Trinity Grammar School

**RE: SSD-10371 Trinity Grammar School redevelopment – Response to Submissions II  
– Traffic items**

This letter has been written to address the second Request for Information (RFI) issued on 11 December 2020 by the Department of Planning, Industry and Environment (DPIE) regarding SSD-10371 for Trinity Grammar School's redevelopment.

Figure 5 - Existing Jubilee car park layout

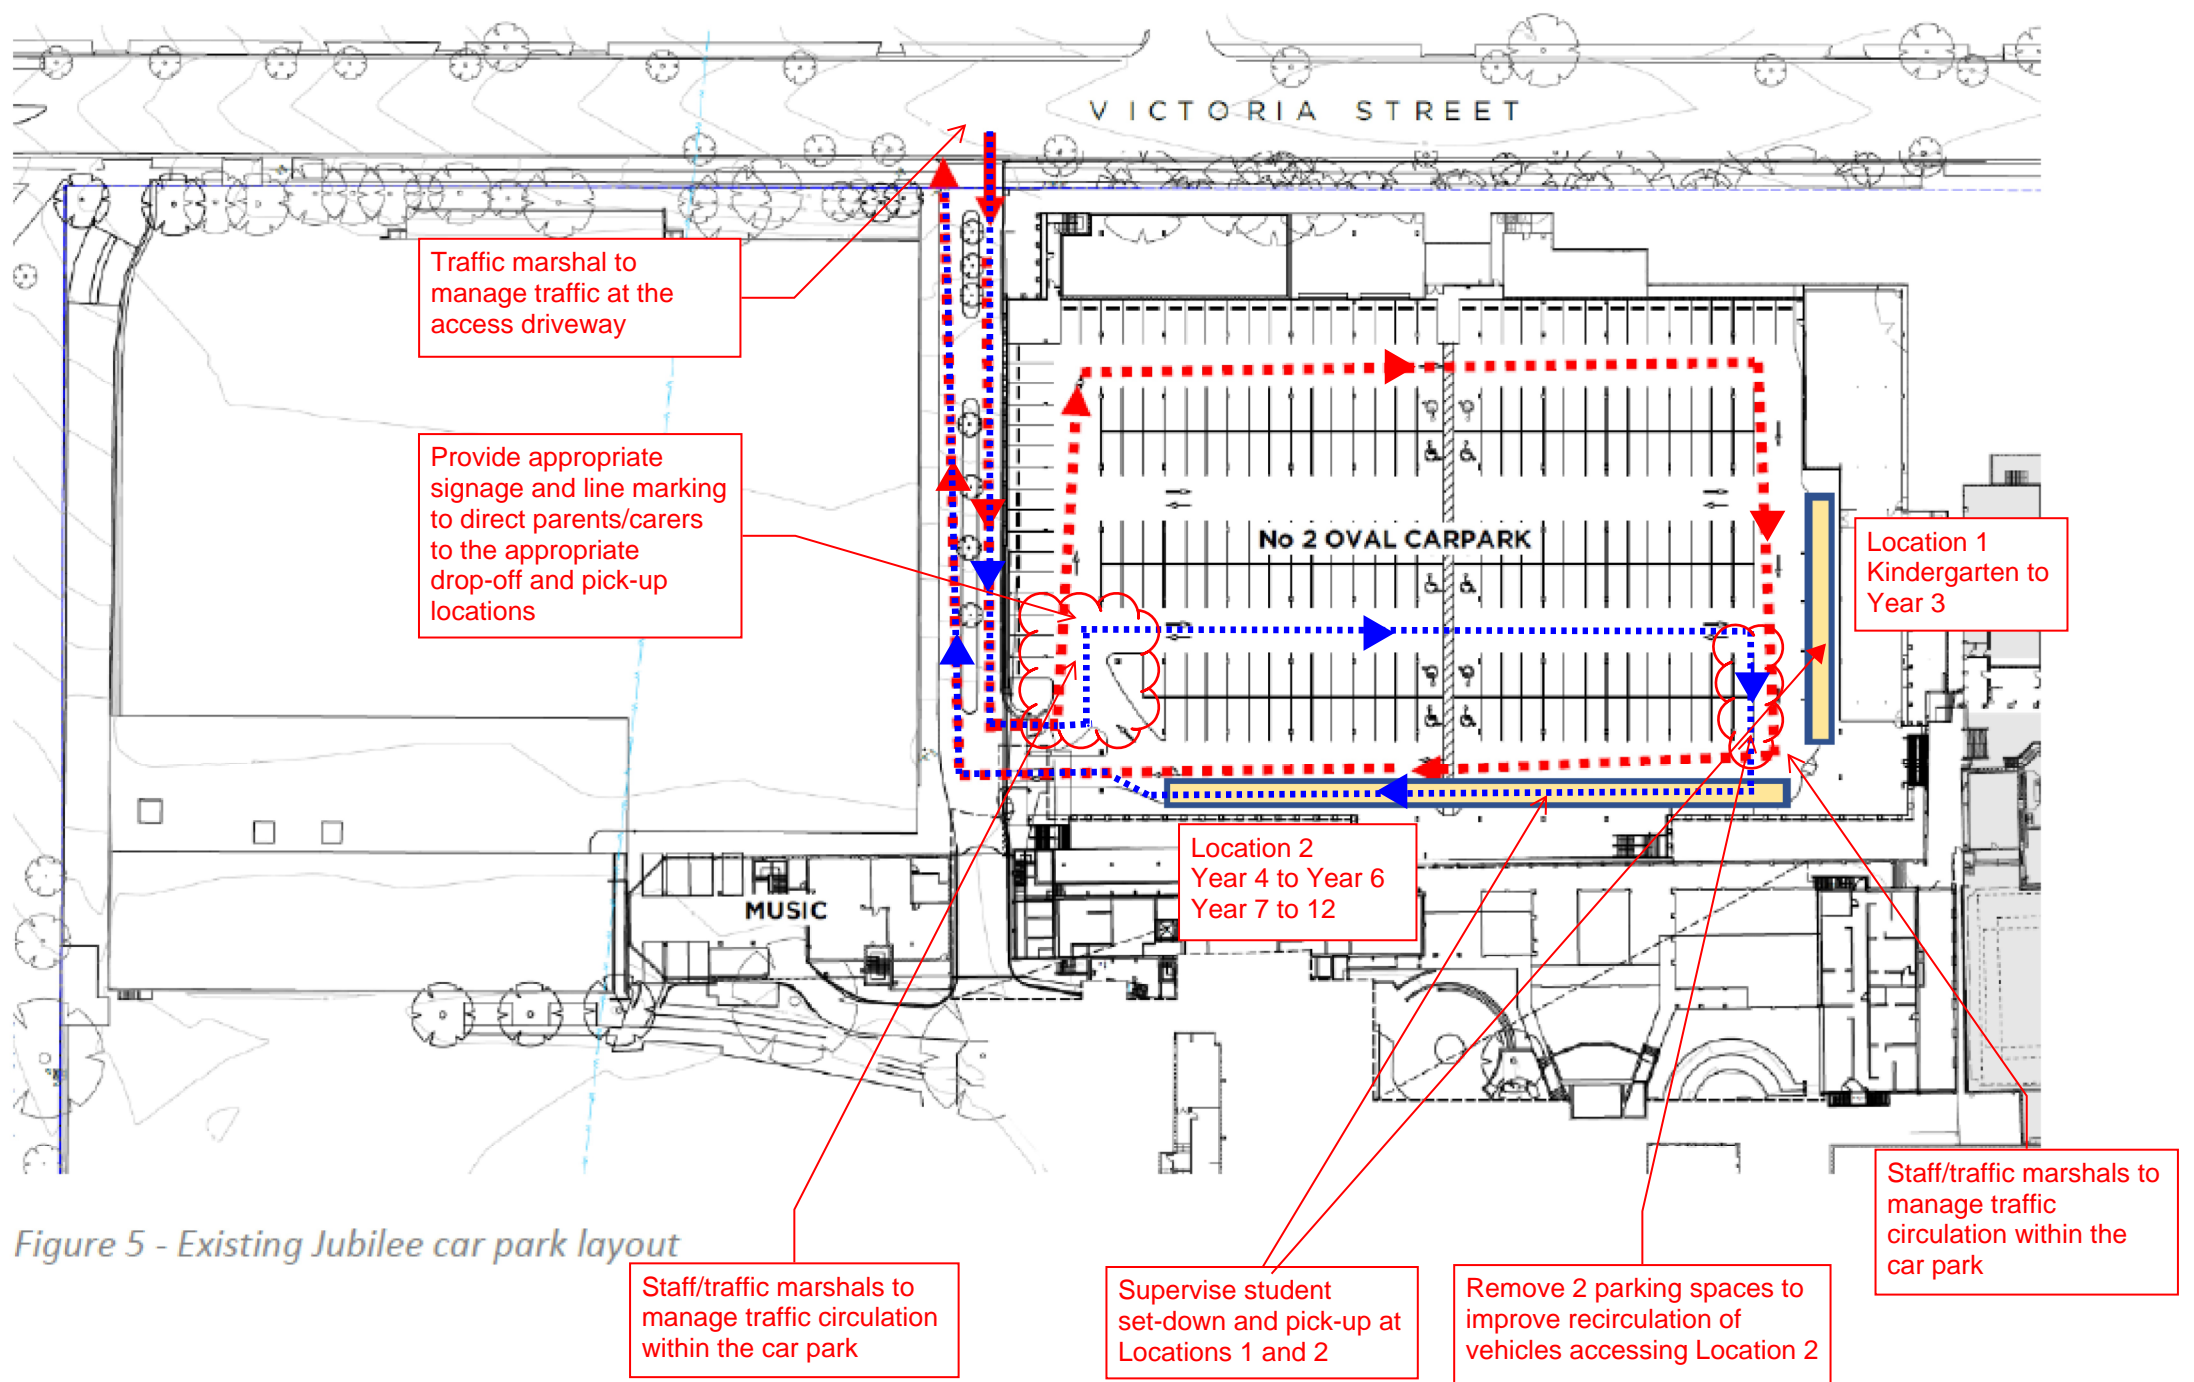
*The Department requests additional information be provided to understand the capacity and demand of the pick-up and drop off area. In this regard the Department notes that the analysis provided with the RtS indicates that under both the existing and the proposed arrangements the pickup/drop off would operate below capacity. However, the Department requires more information to substantiate the assessment as from the details provided in the public submissions and having regard to the previous findings of the NSW Land and Environment Court case (Council of Trinity Grammar School v Ashfield Council [2015] NSWLEC 1086), it appears likely that the current arrangements cannot accommodate the current demand, contrary to the information provided in the RtS. Therefore, the Department requires:*

- a) *detailed information based on surveys and data collection to demonstrate how the existing and proposed demand has been calculated. The Department notes the number of vehicle trips is very different from data provided in the original traffic assessment, and the increase in demand (82 AM trips and 45 PM trips) is inconsistent with the traffic assessment*

- b) *detailed information to demonstrate demand in the 20 minutes immediately before the AM bell and 20 minutes immediately after the PM bell, noting that peak demand is not spread over an hour but is usually concentrated over a very short timeframe. Where demand results in queuing on Victoria Street, an analysis should be provided of any change in queue lengths and time frame for the on-street queue to clear as a result of the revised design and increased student numbers.*
- c) *consideration of impacts on queue lengths as a result of other vehicles accessing the site to park.*

Counterintuitively, the cause for these on-street delays is not actually that too many vehicles are trying to access the car park at once. The delay is caused by vehicles that are using the car park to pick-up or drop-off that are held up by other vehicles attempting to park within the car park. These vehicles parking block the circulation pathway and reduce the total queue distance within the car park which then leads to vehicles queuing back onto the street.

As can be seen in the diagram of the existing car park above (Figure 5), there are many car parking spaces along the wall parallel with Victoria St, along the entry/exit driveway, and the car parking aisles have a north-south orientation. The red dashed line indicates the path of travel for vehicles to circulate through the car park. This path of travel is to access both the pick-up/drop-off area which is marked in yellow, and any other car parking. Vehicles enter and exit out of the one driveway at Victoria St.

With the rotation of the car parking spaces running north-south, the major delays are caused by vehicles parking their vehicles that then block the circulation pathway. As delays

generally occur in the first half of the car park as vehicles first enter, this leaves less room inside the car park for other vehicles attempting to enter which reduces the internal queuing space and results in queues on-street. The fact that queues dissipate within 10-15 seconds on-street confirms that the internal delays are very brief in nature, allowing the on-street queue to clear quickly.

With a desire to remove this impact, the school has taken the approach to design out the cause of the problem by extending and redesigning the car park to lengthen the internal circulation/queue area and to reorient car parking aisles to an east-west orientation. See below for the new layout (Figure 6). This design essentially separates the two functions of *parking* and *pick-up/drop-off* to significantly reduce potential for delays to occur.
